Our Ref: EN010147

Application by Photovolt Development Partners (PVDP) on behalf of SolarFive Ltd for an Order Granting Development Consent for the Botley West Solar Farm

Advice following issue of decision to accept the application for examination

Photovoltaic Development Partners GmbH  
Kurfürstendamm 52  
10707 Berlin, Germany

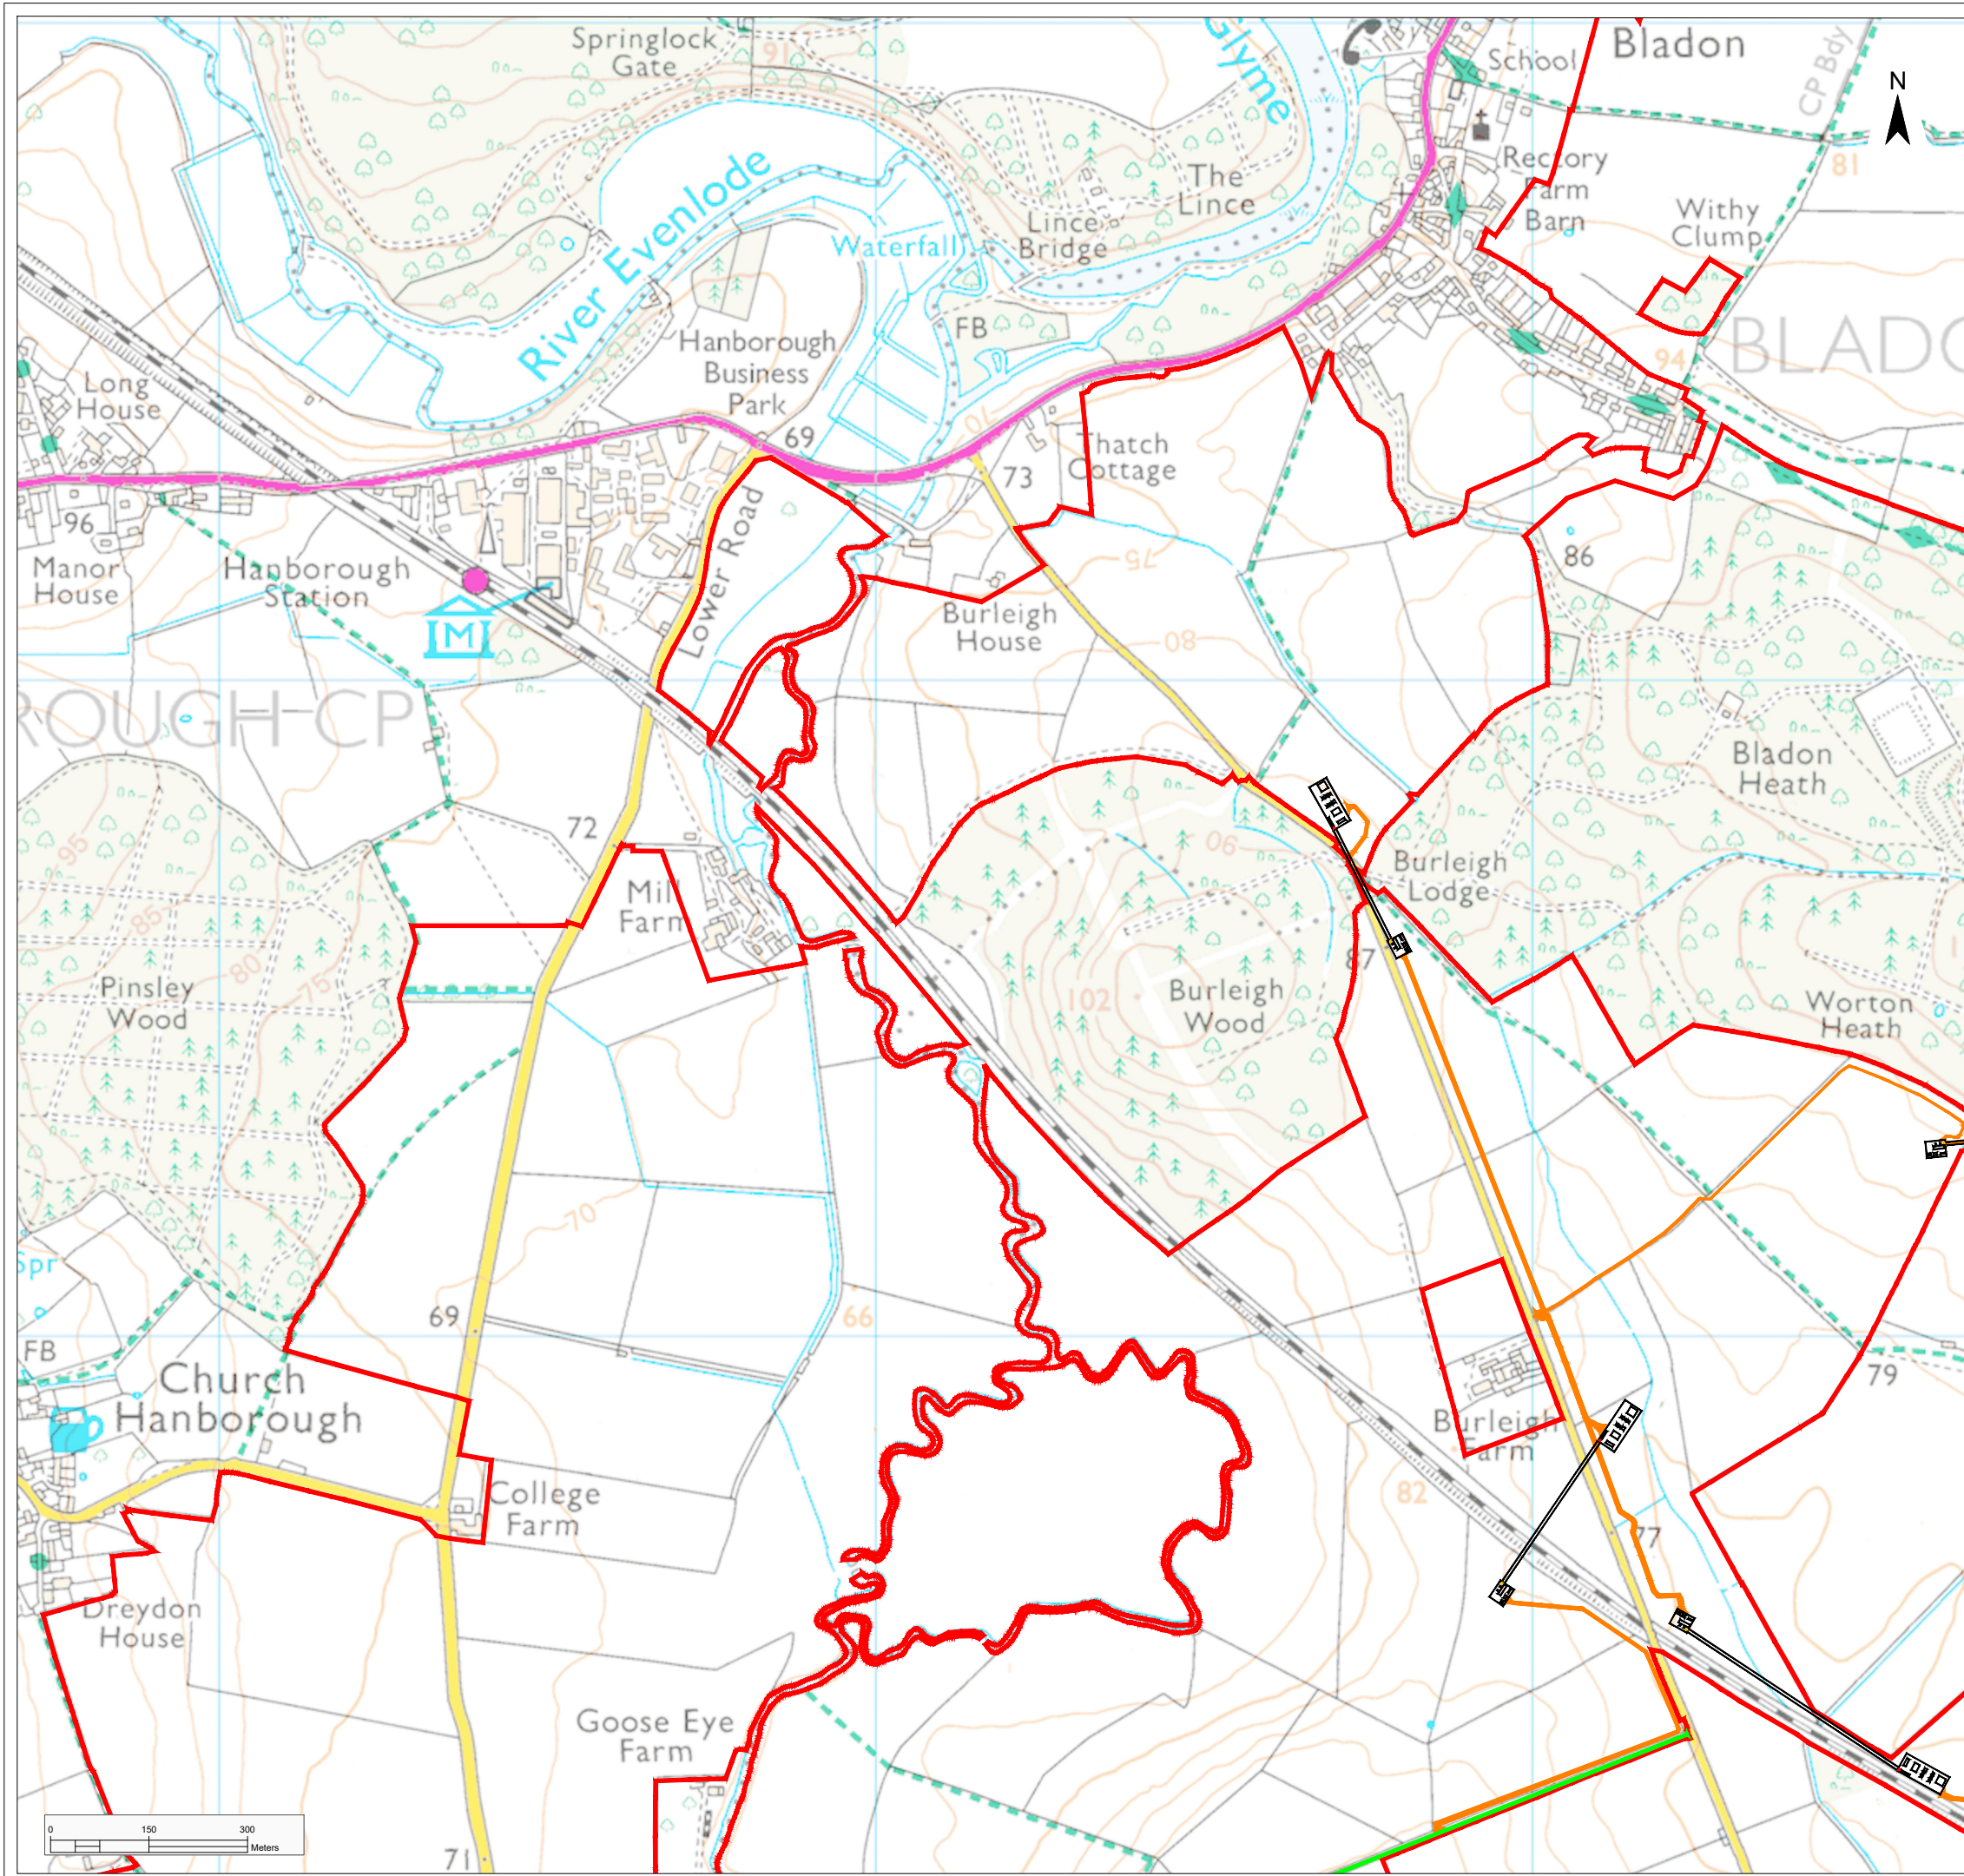
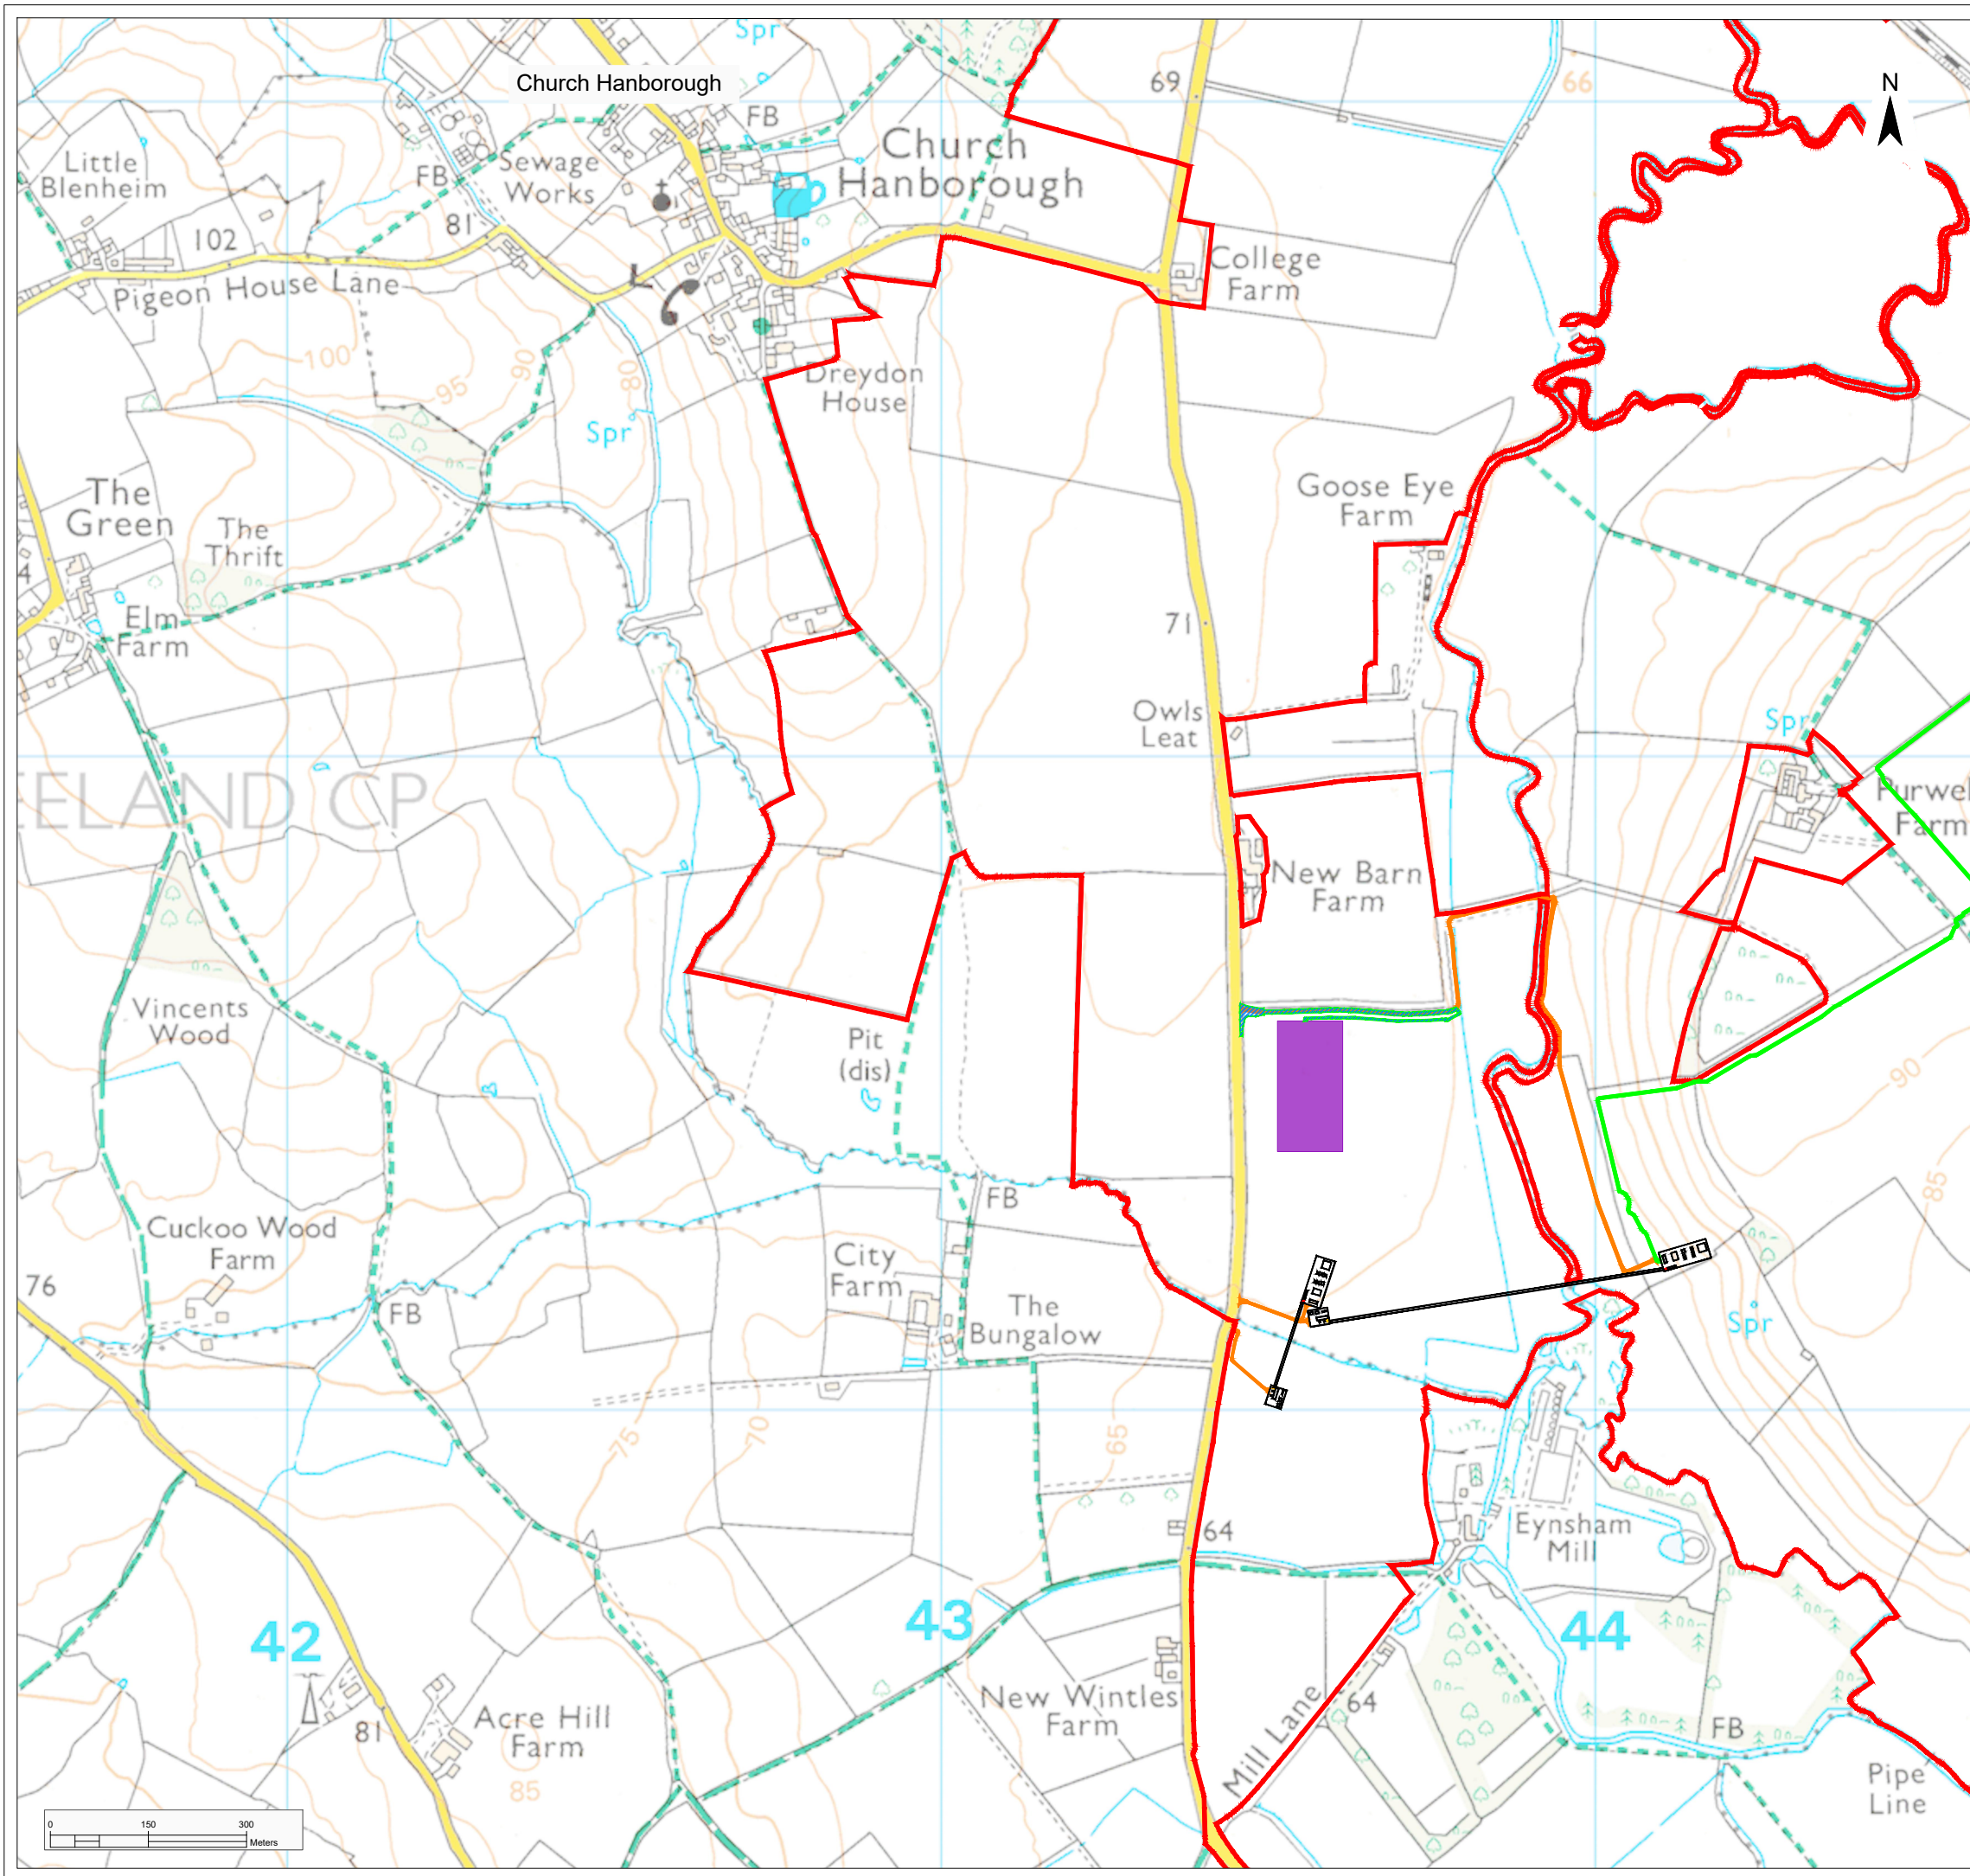
Operational Development Areas Plans (Doc 7.3.2), Landscape, Ecology & Amenities Layer Plan (Doc 7.3.3) and Temporary Facilities Plans (Doc 7.3.4)

The Inspectorate draws the attention of the applicant to APFP Regulation 5 (4A) in relation to these plan documents. The applicant may wish to amend these plans to ensure that the scale being used follows this regulation. For the benefit of the understanding of all parties to a future examination it may be desirable if it was more clearly presented on the plans which areas are within the Order Limits and how the sheet in question fits in the context of the wider site.
